WEST SUSSEX COUNTY COUNCIL CONSULTATION

TO:	Arun District Council FAO: Michael Eastham
FROM:	Highways, WSCC: Tim Townsend
DATE:	17th October 2018
LOCATION:	Land to north of, Toddington Lane, Wick, Littlehampton, West Sussex, BN17 7PP
SUBJECT:	LU/259/18/DOC Application for approval of details reserved by conditions 22, 23, 25, 26, 30 and 44.
DATE OF SITE VISIT:	N/A
RECOMMENDATION:	☒ Advice ☐ Objection ☐ Modification ☐ No Objection ☐ More Information ☐ Refusal
S106 CONTRIBUTION TOTAL:	£N/A

This is the WSCC Local Highway Authority (LHA) response to the above planning application for approval of details reserved by conditions 22, 23, 25, 26, 30 and 44.

Site:	Phase 2 Littlehampton 126 Units	Date:	Aug 2018
Scale:	1:500 @ A1	Drawn:	AT
Org No:	543_PL_CMP	Rev:	
Drawing Title:	Construction Management Plan		
Drawing Status:	SUBMITTED

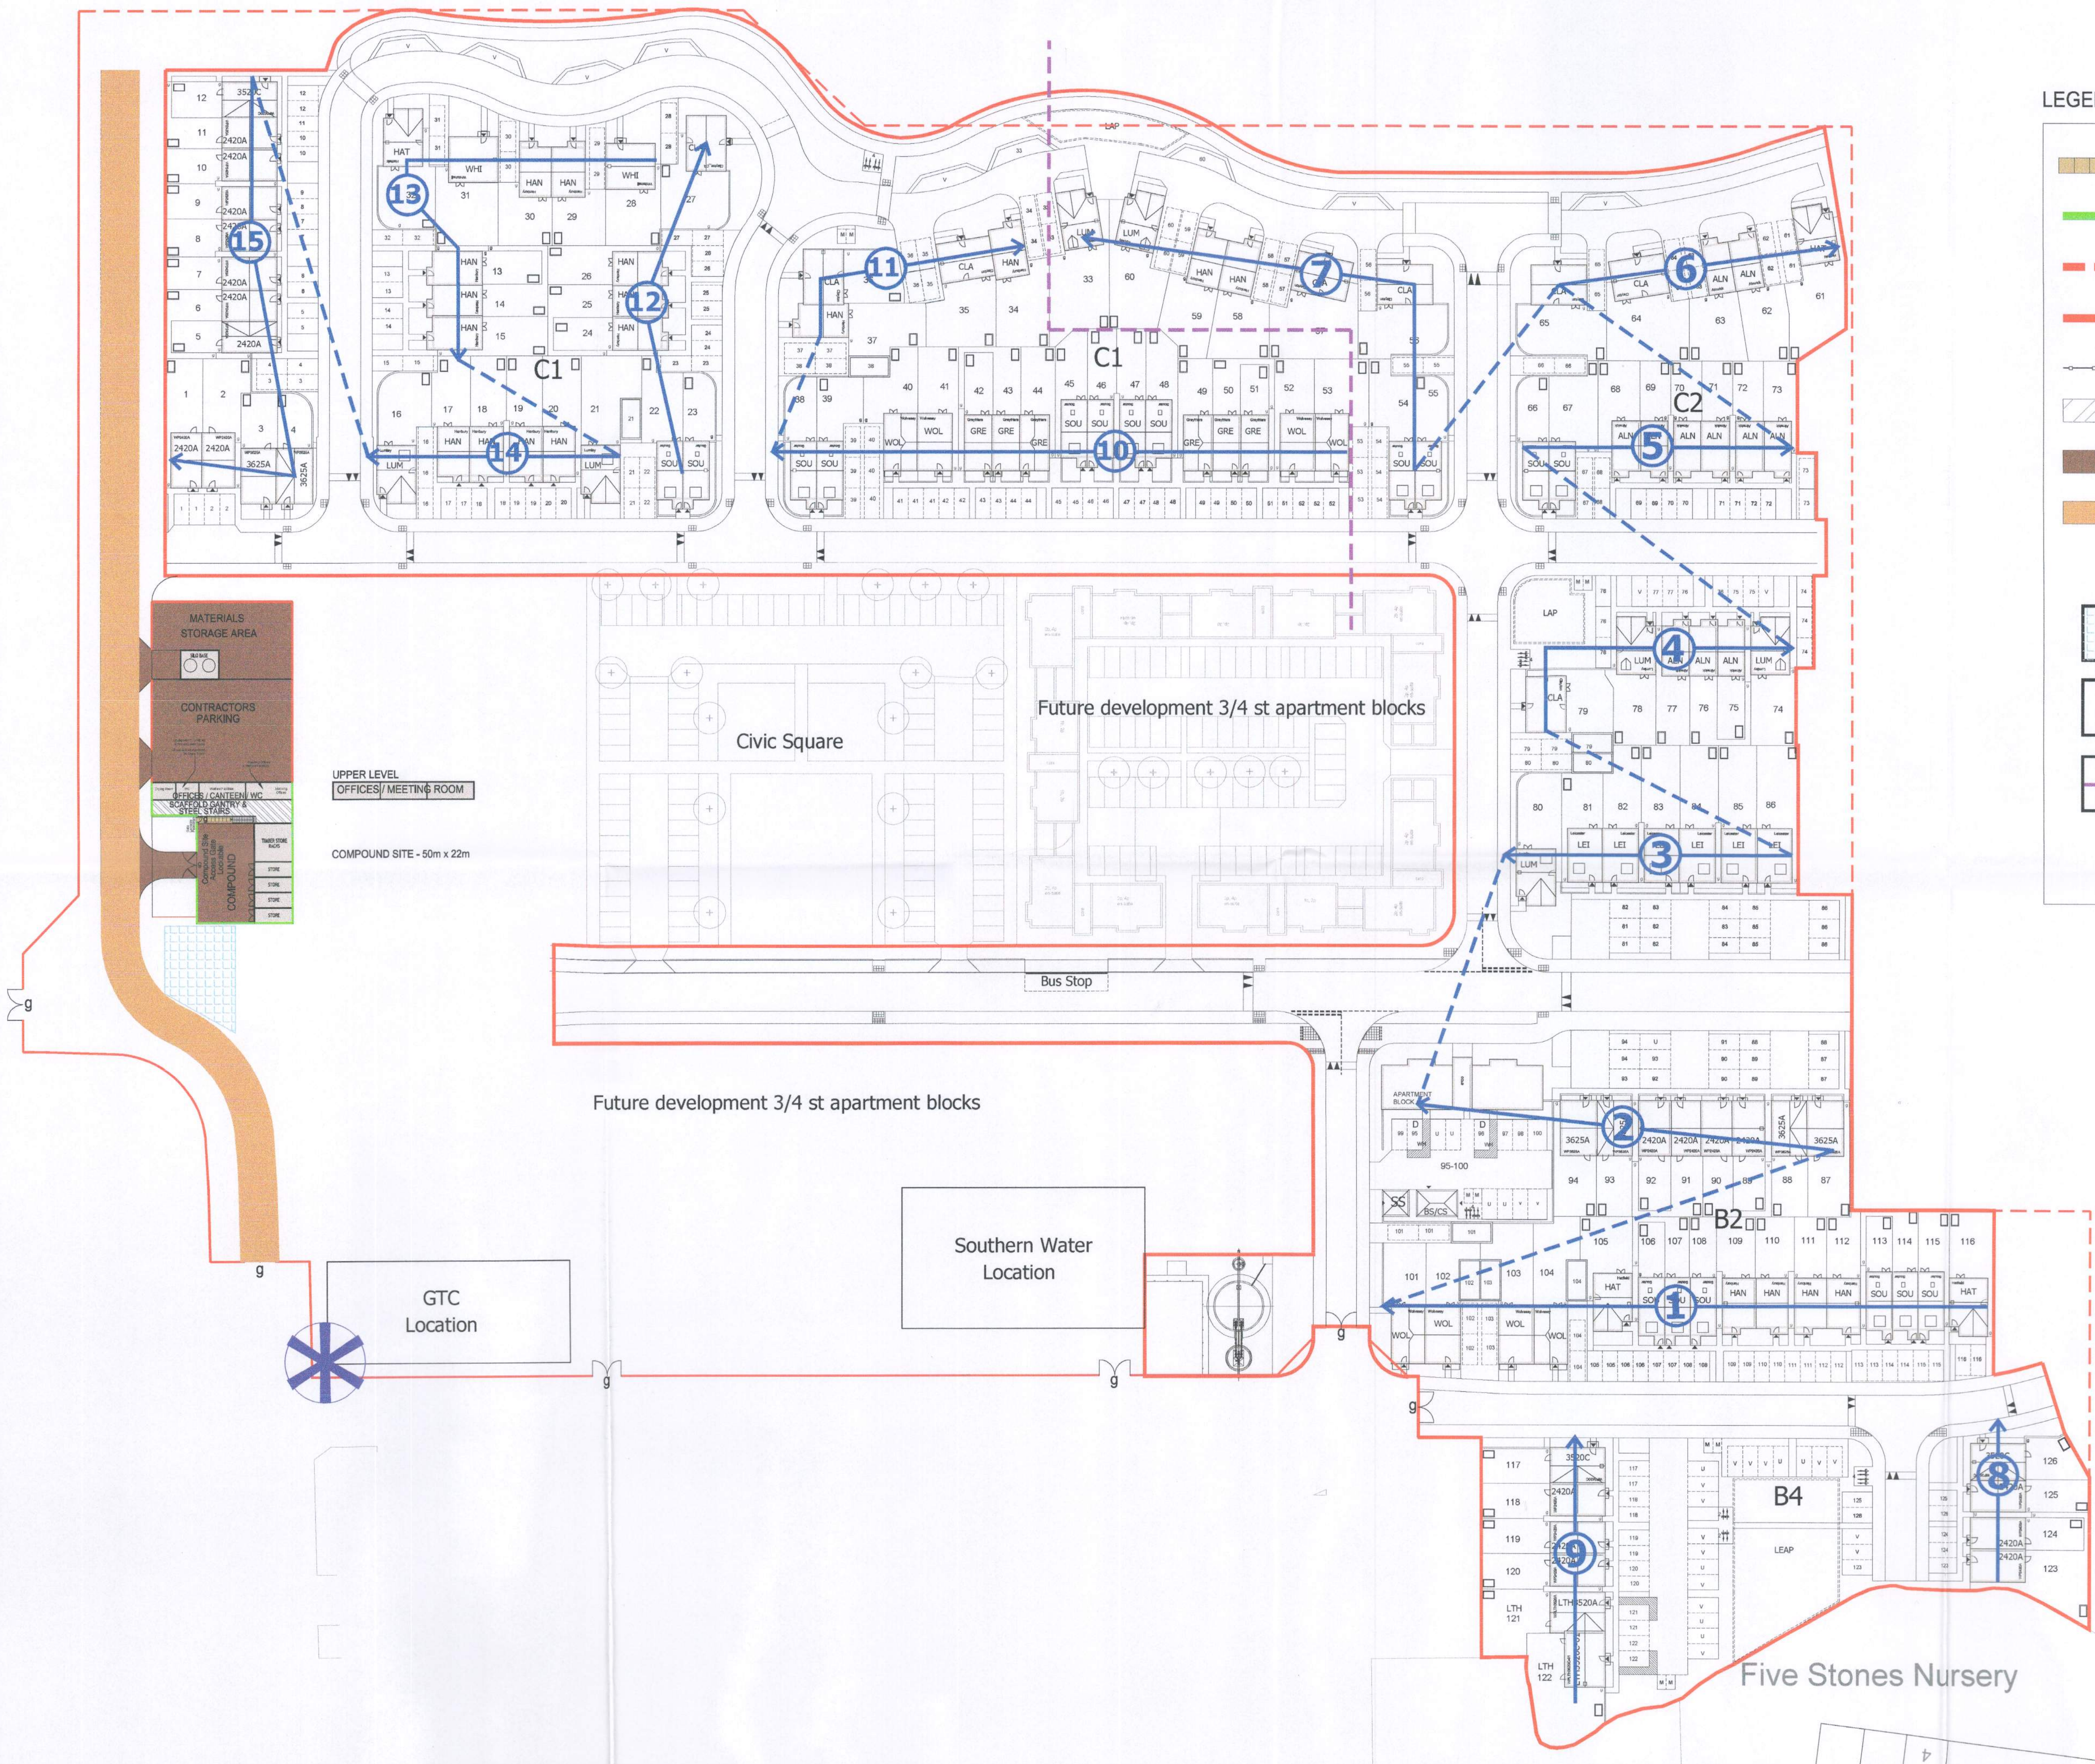
1. Condition 22 (Construction Method Statement) – *No highway objection subject to adding out-of-hours contact details.*
2. Condition 23 (Construction compound) – *No highway objection.*
